Recommendation Report for Planning Permission for Works or Extension to a Dwelling

REF NO: BN/60/18/HH

LOCATION: St Annes Cottage
Lake Lane
Barnham
PO22 0AJ

PROPOSAL: Loft conversion with dormers to front and rear of roof. New roof over existing rear extension and new enclosed porch.

Proposed Extension and Alterations
at St Anne's Cottage, Lake Lane, Barnham
for Mr and Mrs B Geldenhuys
Drawing P01a November 2018 Scale 1:100 & 1:500 @ A3
Planning Drawing - Ground Floor & Block Plan & Elevations

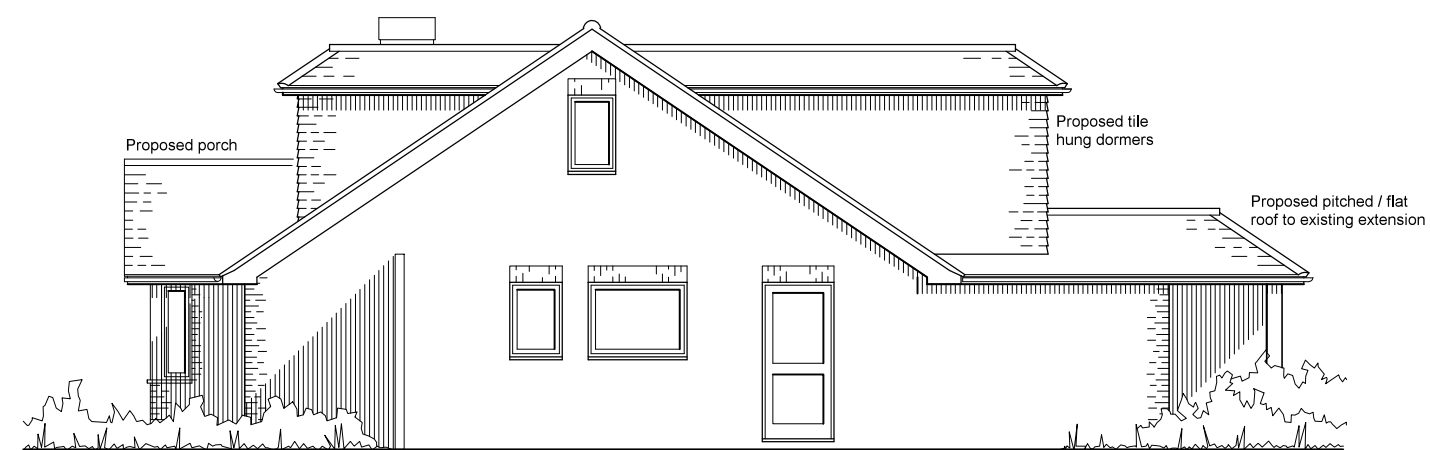
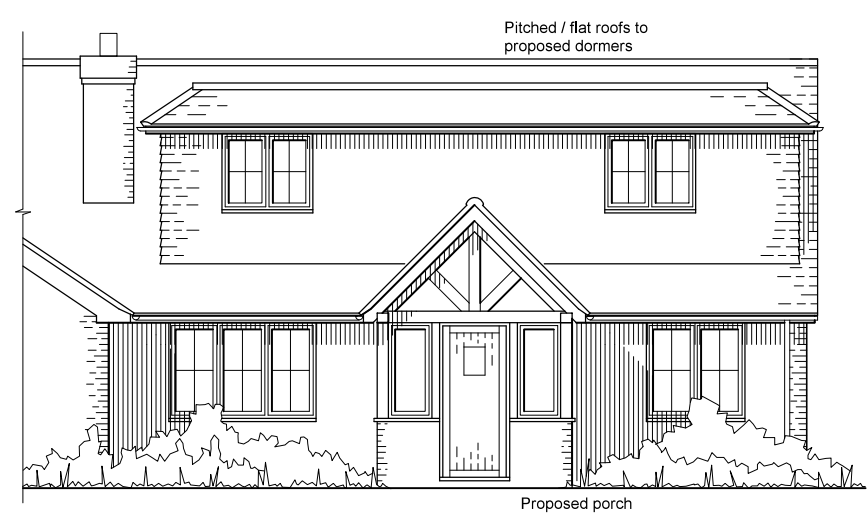
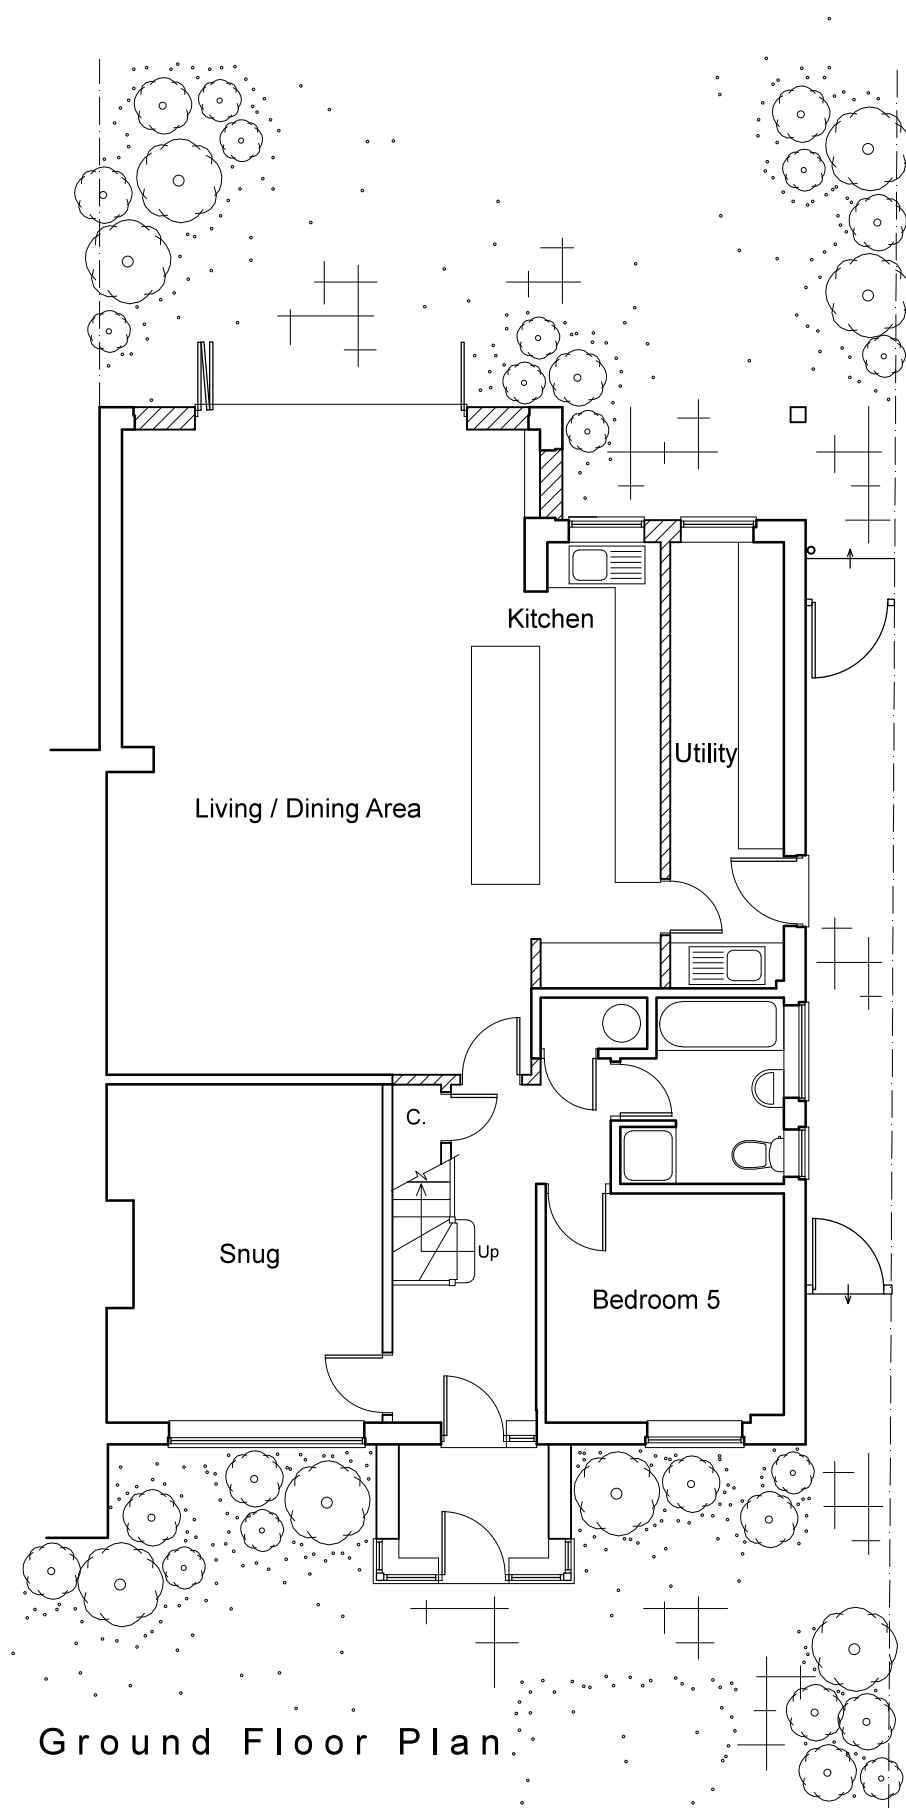
The proposal seeks to construct a dormer and a gabled roof porch to the front elevation. This meets in line with the principal elevation of the neighbouring property. Due to its siting at the front of the property, it is not considered to appear overbearing or overshadowing upon neighbouring amenity, with any additional views over the street scene.

To the rear the existing extension will have a replacement roof with the depth to remain as existing. The height will however increase slightly with the alteration of the roof type to a height of around 3.2m. The eastern side of the rear extension will also be infilled to a depth of 1.85m and a width of 3.3m. This is modest and with 1.2m separation to the boundary it is not considered to give rise to any overbearing or overshadowing to the neighbouring properties to the east.

Proposed Extension and Alterations
at St Anne's Cottage, Lake Lane, Barnham
for Mr and Mrs B Geldenhuys
Drawing P02a November 2018 Scale 1:100 & 1:1250 @ A3
Planning Drawing - First Floor, Roof & Location Plans & Elevations

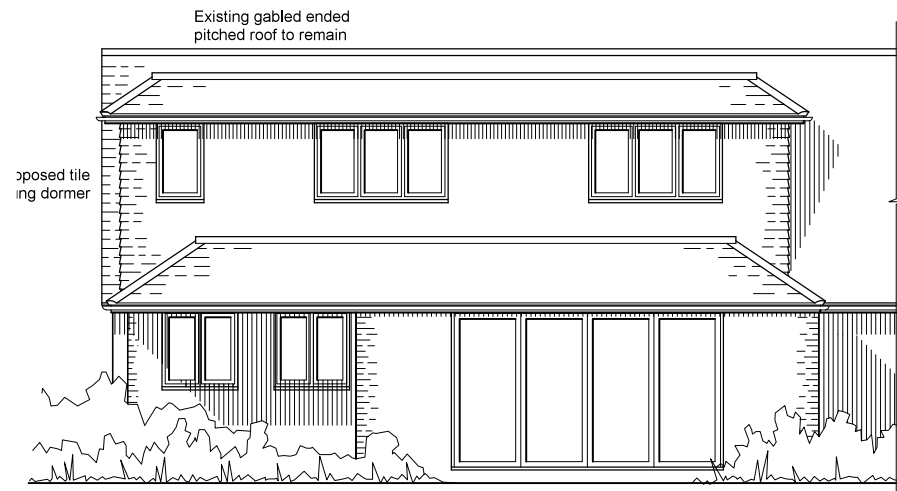
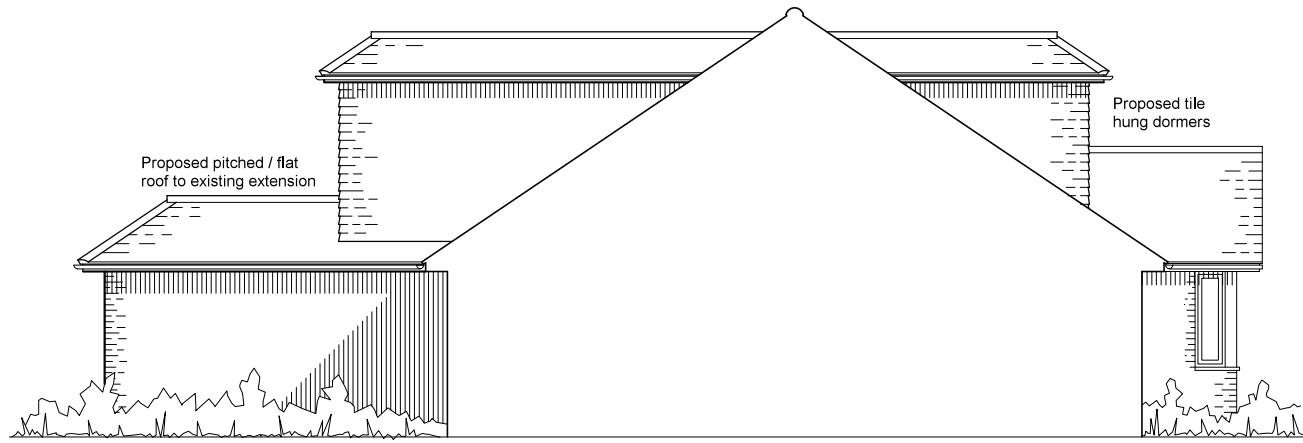
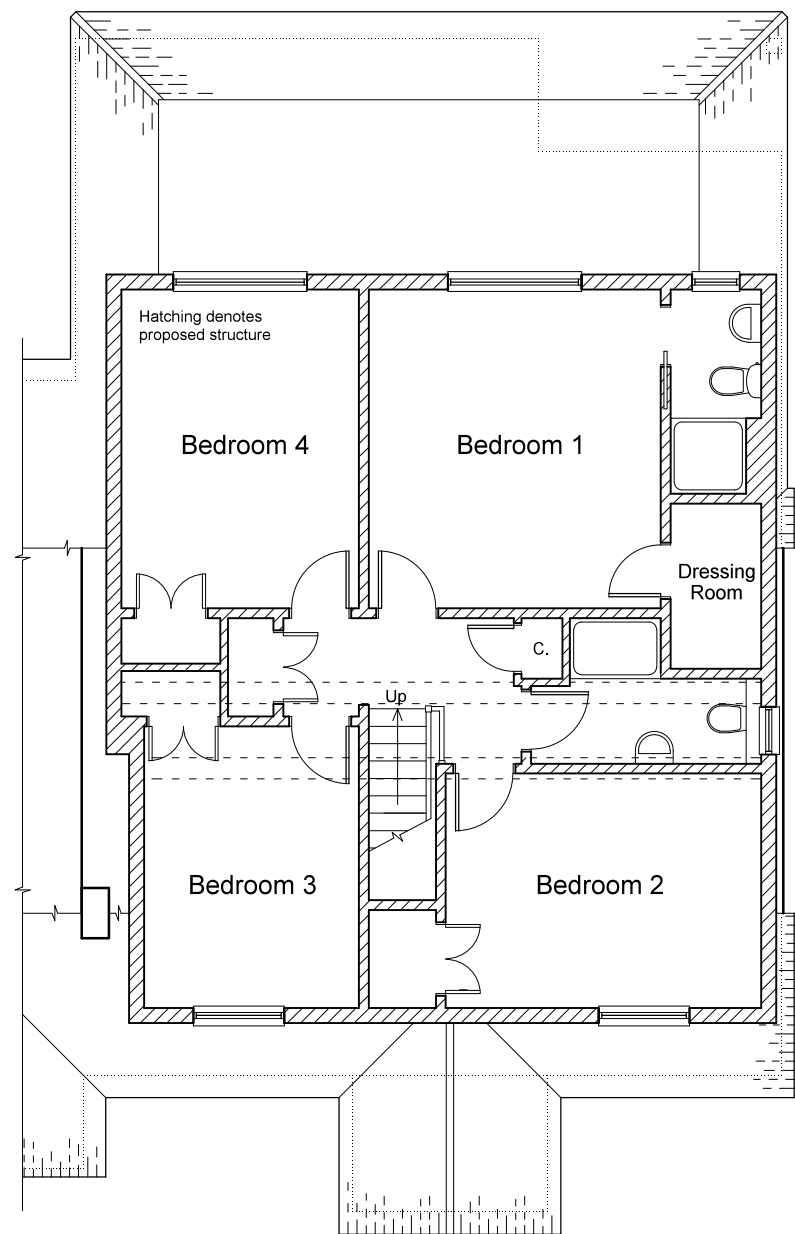
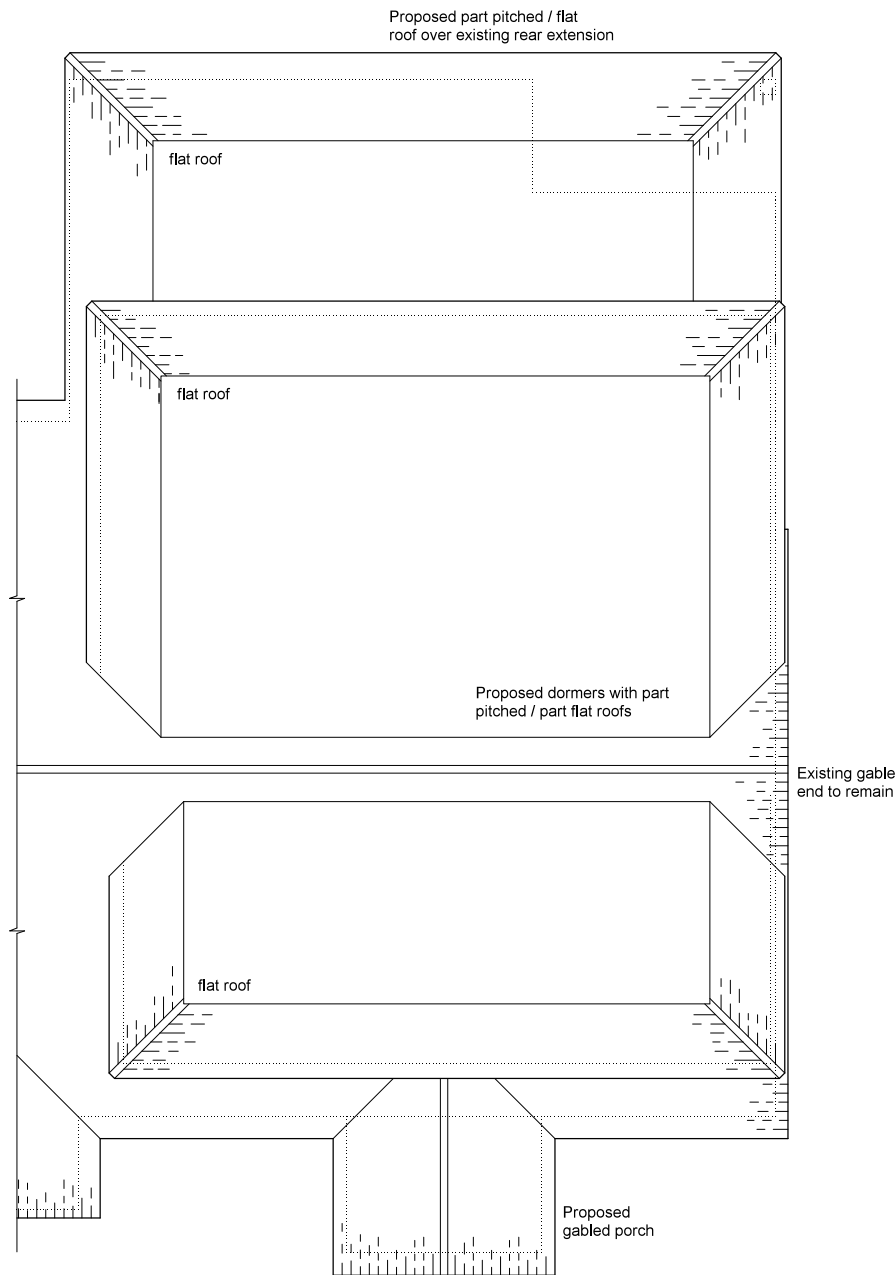
Due to the scale of the dormers they are not considered subservient to the host dwelling and as a result the proposal is in conflict with DDM4 (b) of the Arun Local Plan. The proposal is however well integrated with materials to match that of the existing dwelling. The surrounding properties are of a mixed design and style and as such the proposal is also not considered to appear out of character with the area.

A dormer to the rear is also proposed. This is large and extends beyond the existing roof slope to the flat/pitched roof extension. The dormer extends the full width of the roof and has a depth of approximately 5m and a height of 2.75. Whilst this is large and may appear overbearing upon the neighbouring property at 'Pipkins', it is not considered the impacts are significant in which a refusal would be justified. To the eastern elevation there is an access road and as a result the development does not give rise to any significant impacts upon this elevation.

3 windows are proposed to the rear dormer and due to their siting and with no neighbours to the rear it is not considered they give rise to any adverse overlooking upon neighbouring amenity.
